With this resubmittal, CGS received a request to provide Review Comments (Email dated October 9, 2023); Letter of Intent (N.E.S., Inc., October 2023); Sketch Plan (N.E.S., Inc., June 5, 2023); Soils and Geology Report (HDR, June 2023); and other documents. The applicant requests a Sketch Plan to permit a new railroad spur through the property to service Fort Carson and associated railroad-oriented heavy and light industry and commercial uses that encompasses 3100 acres of land.

SKETCH PLAN OVERALL MAP

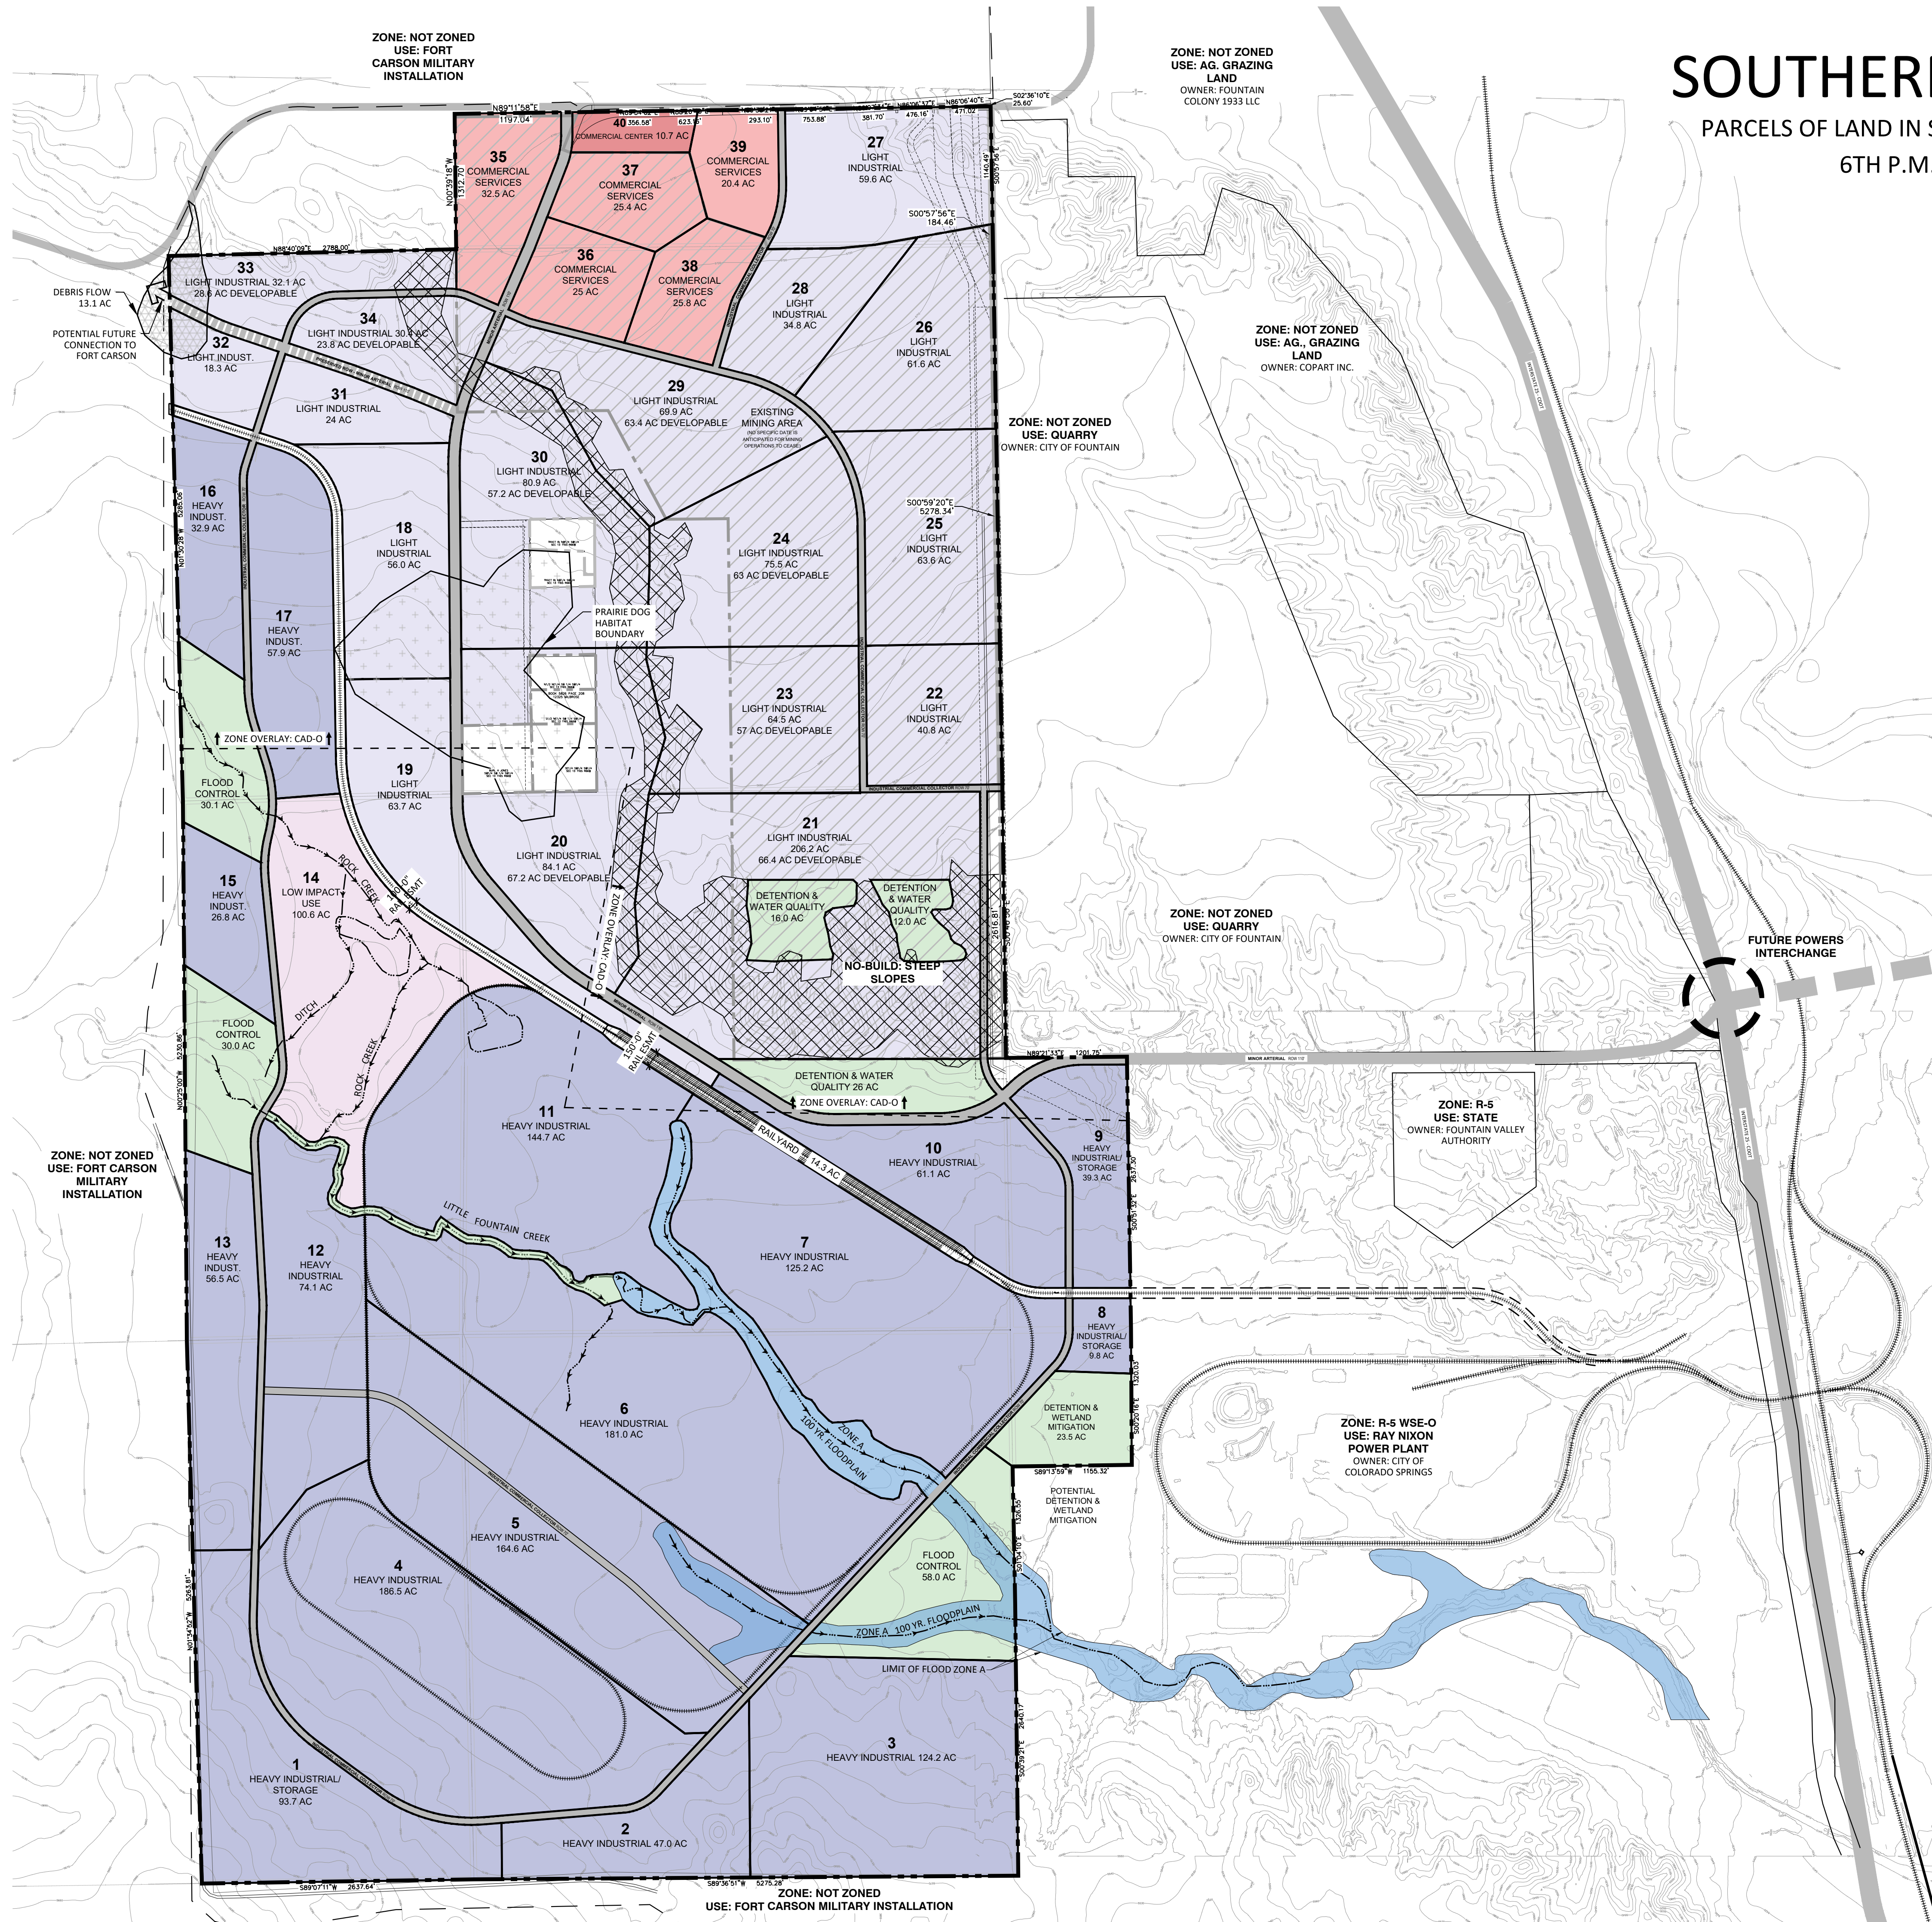
**Floodplain and erosion setbacks:** The Little Fountain Creek traverses the southern portion, and Rock Creek traverses the northern portion of the project area. Little Fountain Creek is designated a 100-year FEMA floodplain (FIRM Panel No. 08041C0965G and 08041C01155G, December 7, 2018) and described as "Zone A". Erosional setbacks from the creeks or any drainage/channel within the site should be established along with site grading that provides positive surface drainage and BMPs for stormwater. A slope stability analysis should be conducted in areas with steep slopes (>20 percent), or areas with slopes designated as unstable or potentially unstable. In addition, flooding and scour erosion mitigation for rail and road crossings should be implemented and maintained.

- The soils and geology report is expanded/updated to include all the geologic constraints to development.
- A geologic hazard and constraint map is included in the soils and geology report and preliminary plans.
- Erosional setbacks from Rock Creek, Little Foundation Creek, and other drainages/channels within the parcel are established.
- Site-specific investigations with geotechnical borings are performed to characterize soil and bedrock engineering properties such as expansion/consolidation potential, density, strength, water content, etc.
- Shallow groundwater is investigated using site-specific monitoring for season variations. Yearly precipitation data, in conjunction with the monitoring program, should be used to evaluate expected variation in groundwater elevations.
